Date: 12 October 2023

Order Granting Development Consent for the Cottam Solar Project (EN010133) – Deadline 1 submission – Written representations

1.1 On 23 March 2023 the Environment Agency made relevant representations to the proposal by Cottam Solar Project Limited to construct a solar farm with sites north-east and south-east of Gainsborough in West Lindsey.

Figure	Cable Route Crossings		
Job	Cottam		
Client	Island Green Power		
Figure No.	1	Revision	A
		Date	04/11/2022
Drawn	BB	Checked	JR
		Scale	1:70,000 @ A3
Job No.	21-1088.01		Central GR
			485466E 387794N

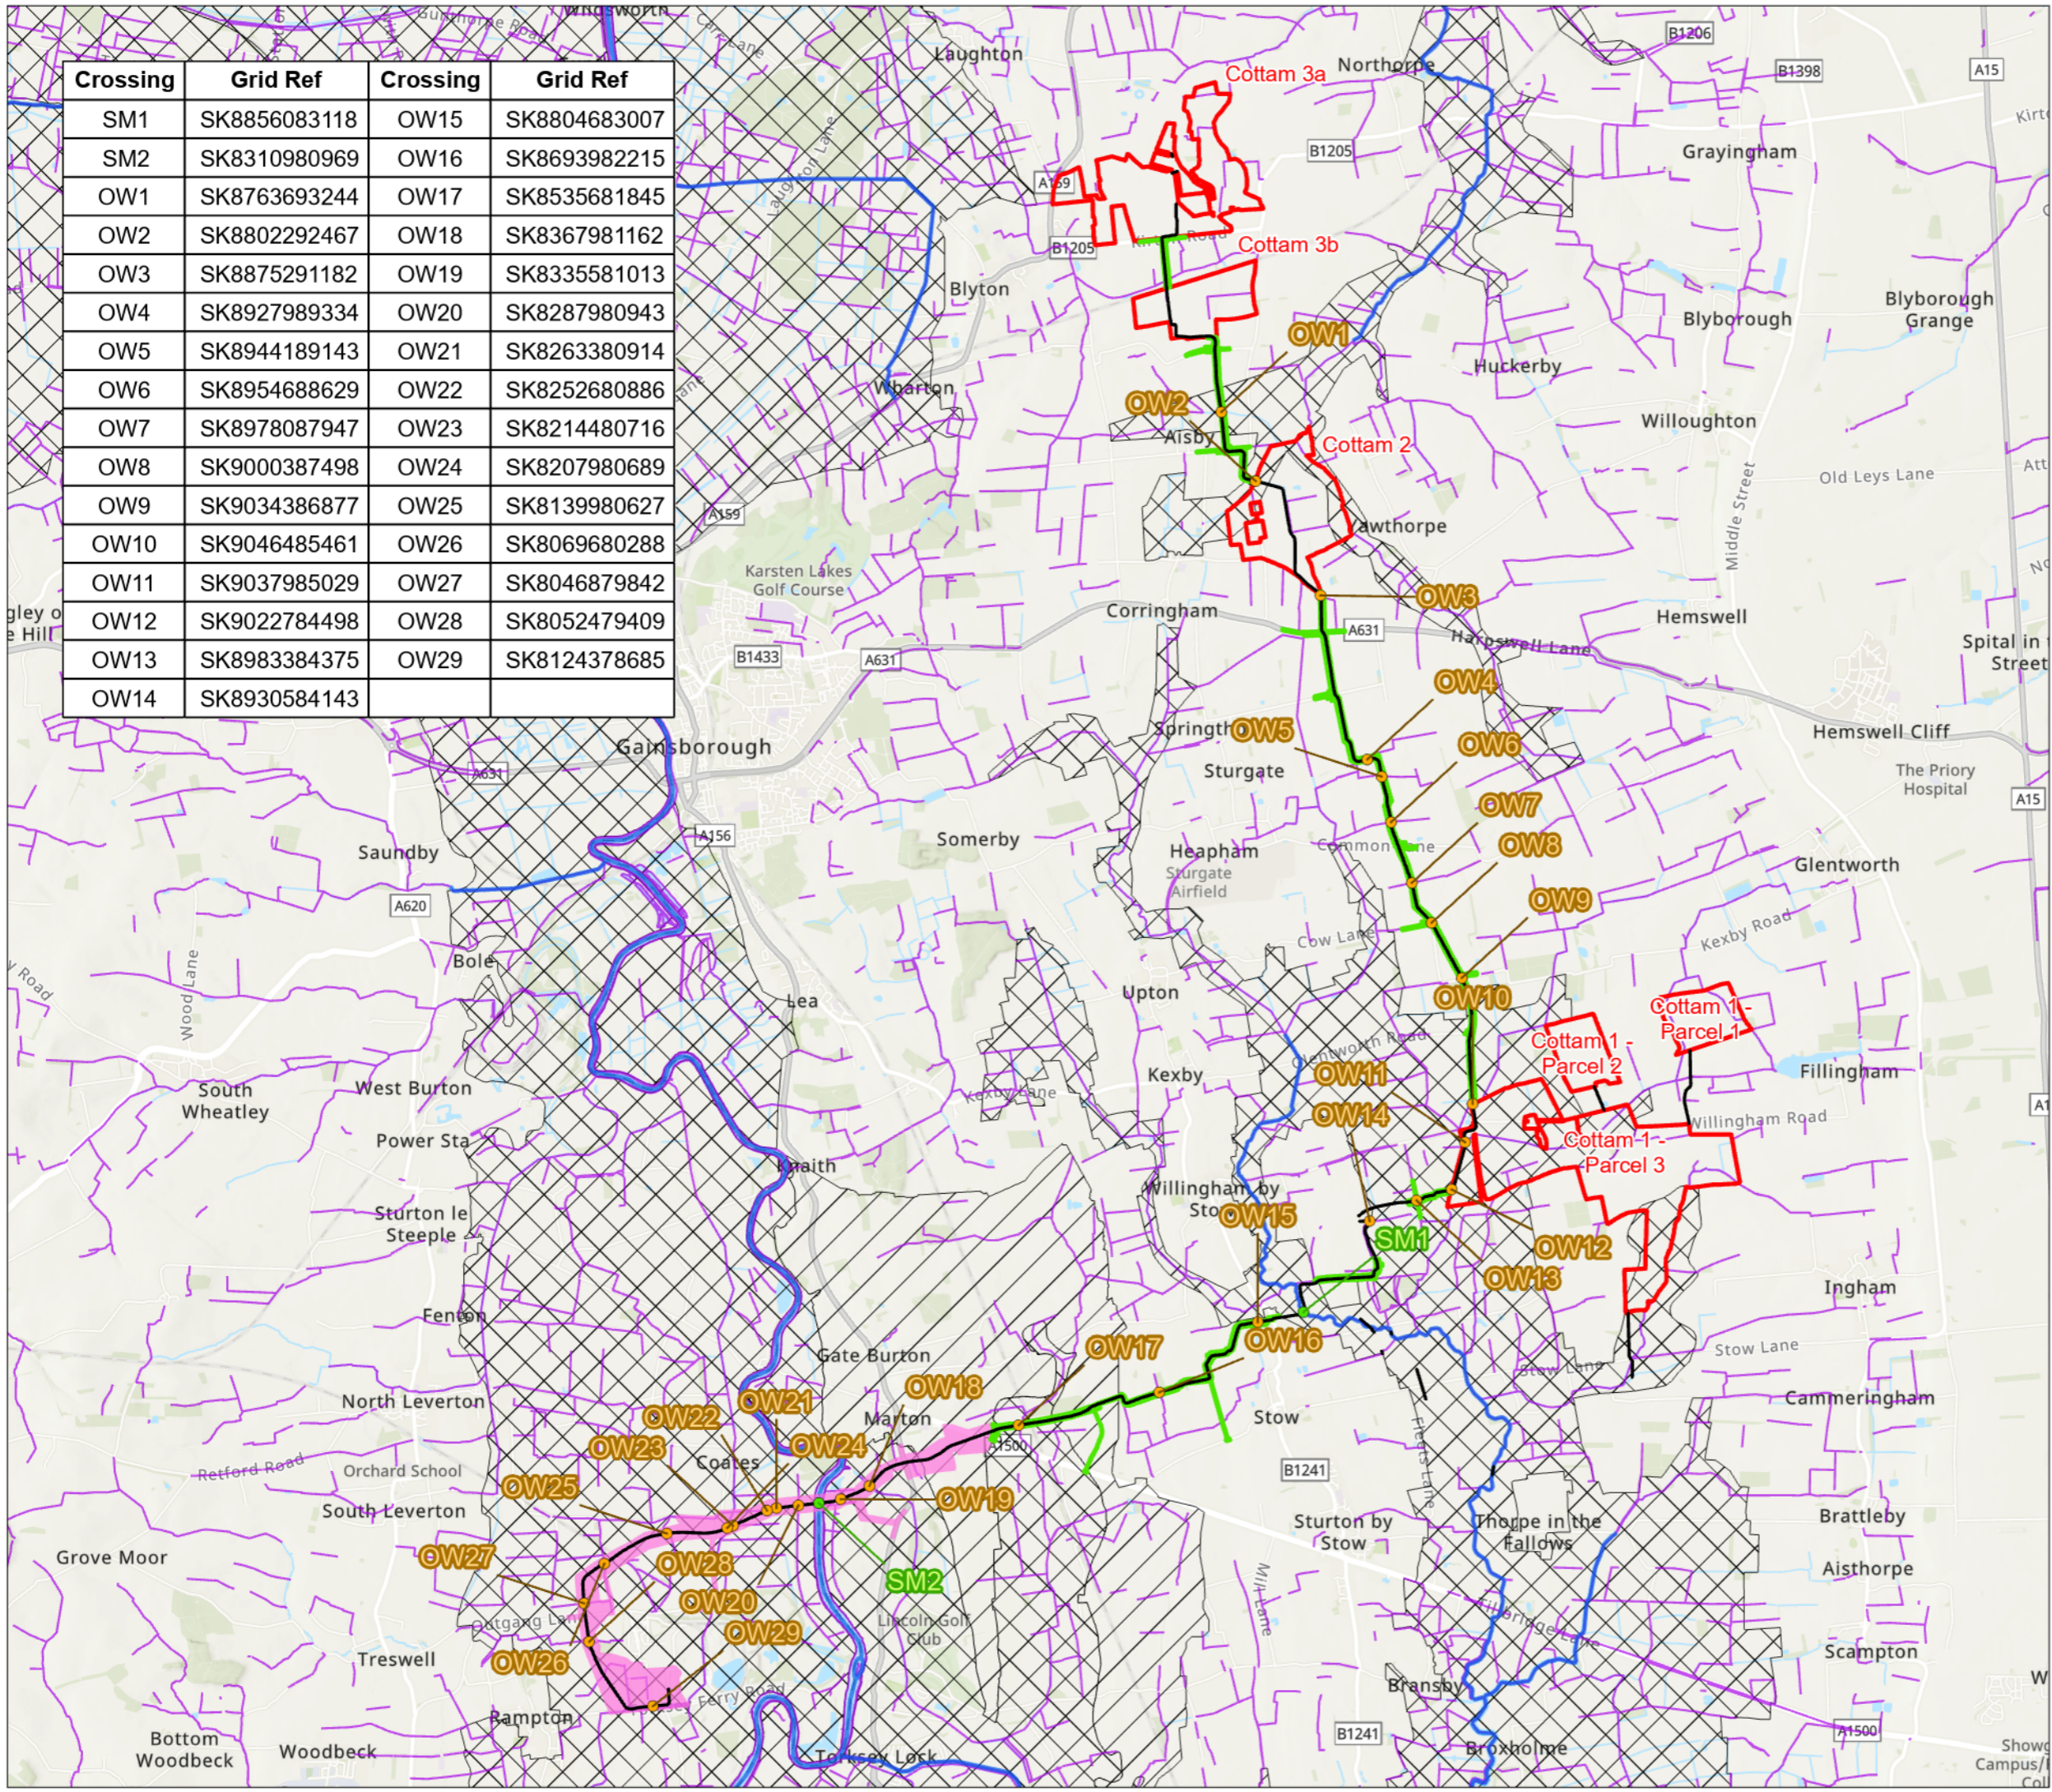
3.2 However, an additional point has been raised with the applicant on the potential impact from the presence of electromagnetic fields (EMF) on ecology where the grid connection corridor proposes to go underneath the River Trent.

3.4 Given that the potential impact of EMF on ecology is an emerging issue and not assessed within the ES we would suggest a risk assessment is carried out, centred on the grid connection corridor to fully understand the risks during the operation of the proposed development.

3.5 As the potential impacts from EMF are dependent on the intensity of the emission, current type, cable characteristics, power transmitted and other surrounding environmental factors a risk assessment would evaluate whether the EMF associated with the proposed development is likely to have any impacts on fish.
